RE: Section 75W modification to Scottish Hospital (MP 10_0016 MOD3) Item 3 Trees

I am writing to on behalf of the Owners Corporation of Strata Plan 11374 at 40 Stephen Street Paddington, regarding the recent application for modification of an existing approval that requests the replacement of the proposed palms to the Stephen St frontage with additional Weeping Lilly Pilly (*Waterhousea floribunda*).

Existing weed tree species proposed for staged removal
From arborist report:

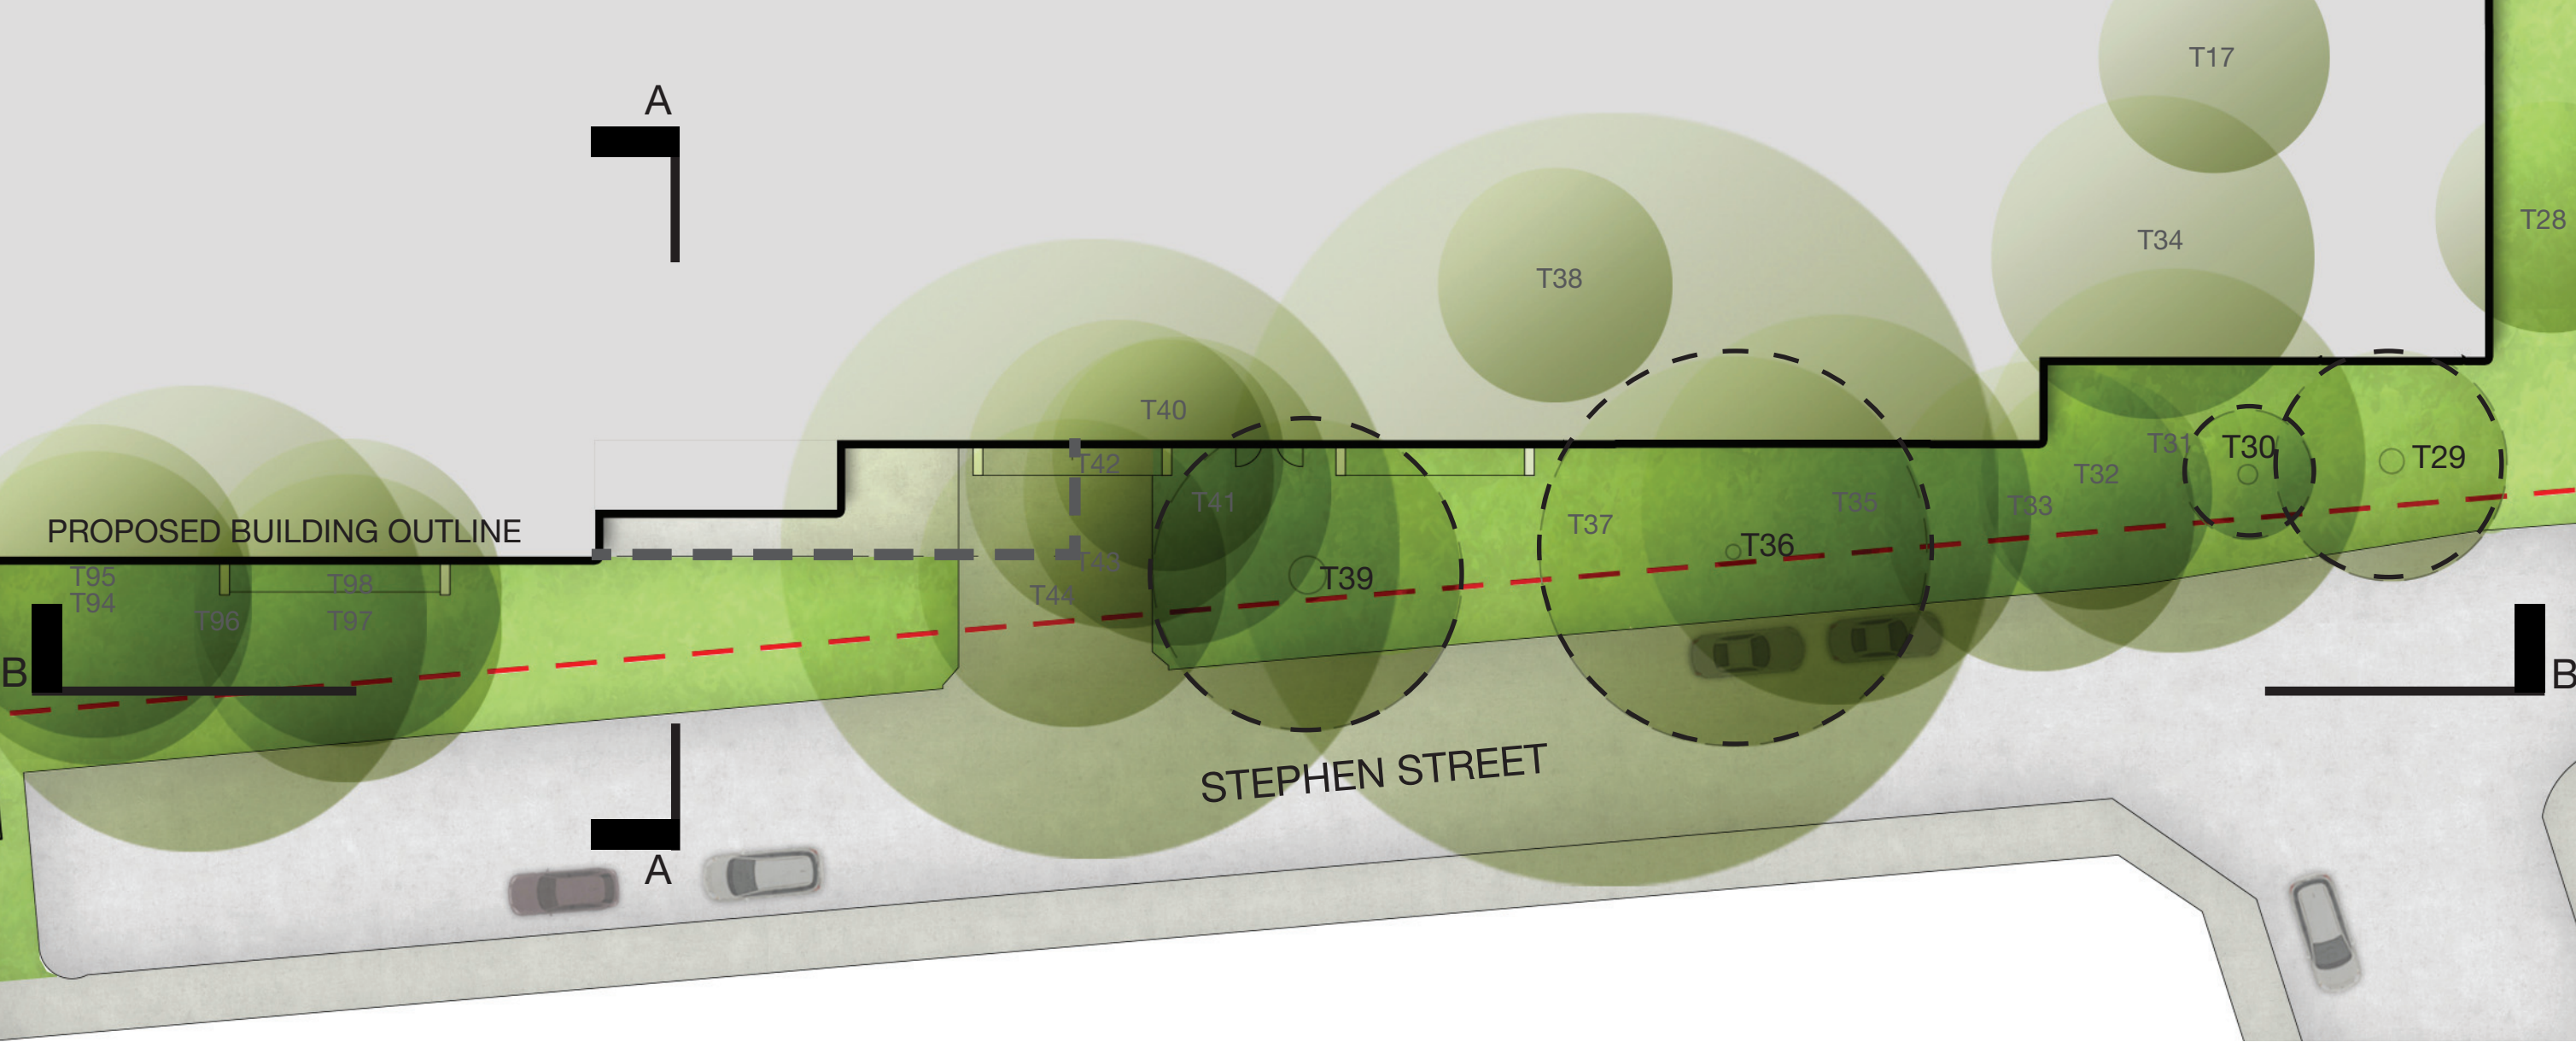
Additional to the original approval that required staged removal of indigenous tree species from Stephen St the applicant sought additional approval from Woollahra Council on approximately the 23rd February 2015. This resulted in the immediate removal of a number of the last two remaining trees on Stephen St (see attached image 2) that were required to be kept under the original approval so as to maintain some tree cover to Stephen St, these are T36 and T39 in the original approval documents (DoP Major Projects website - Determination – Approved Landscape Plans Sheets 1-10) as shown on 'approval drawing' Location Plan sk-01 Rev. B (Sheet 9 attached) from Aspect Landscape Studios.

The approved landscape drawings also show on Sheet 10 (attached), the approved landscape scheme for the Stephen St frontage shows the retained trees as identified above in addition to relocated palm trees, thus resulting in a variable planting scheme to Stephen St. The removal of the existing trees and the current request to locate the palm trees to other areas of the site will result in a 'monoculture' of Weeping Lilly Pilly to the Stephen St frontage. This monoculture is not representative of the fine grain of Paddington but is rather appropriate as a motorway landscaping

Note Option 2:
- Four selected weed trees will remain at the initial planting stage with infill planting of an advanced row of *Waterhousia floribunda*. Weed trees are proposed to be removed in 3-6yrs and replaced by an additional *Waterhousia floribunda*

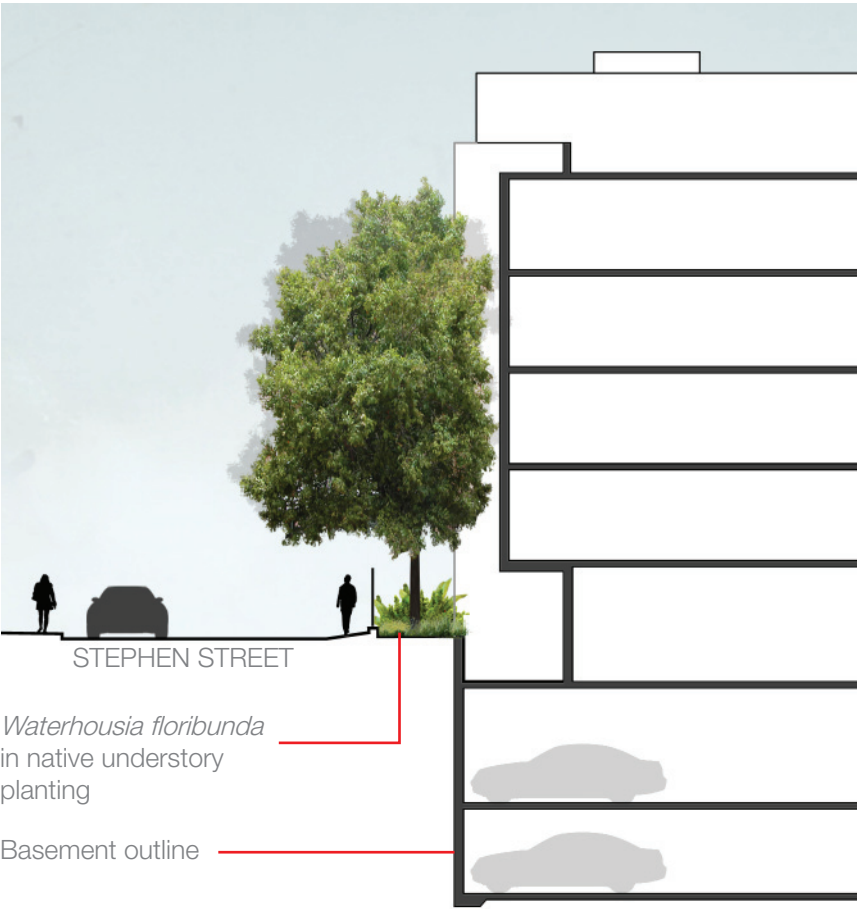
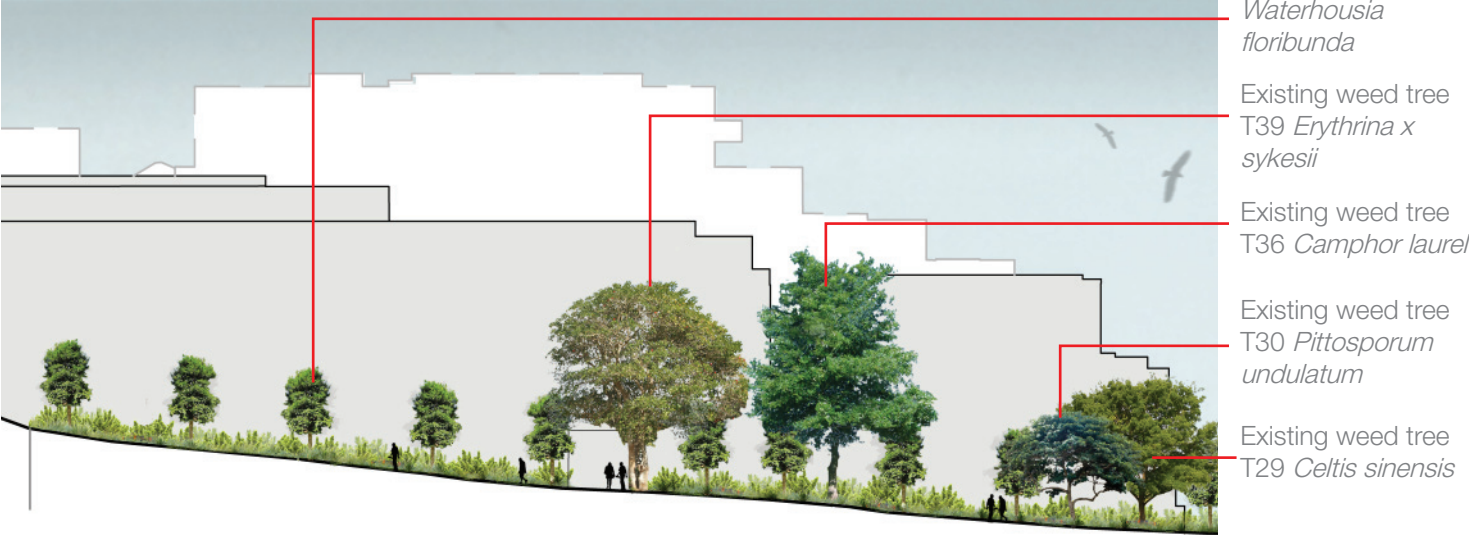
treatment. Additionally the Weeping Lilly Pilly are not successful in reaching a significant size in the immediate locality as evidenced by the Weeping Lilly Pilly used as street trees in Glen St, approximately 50m east of the proposed location on Stephen St. The at Weeping Lilly Pilly opposite 16 and 18 Glen St Paddington have been 'struggling' to achieve growth and remain the size of juvenile specimens, this species will not achieve a 'screen' of any type in the proposed location. (see attached image 3).

The Owners Corporation of SP 11374 at 40 Stephen Street Paddington request that the application for alternate placement of the palm trees be denied and that greater variation in the streetscape plantings to Stephen St be upheld.
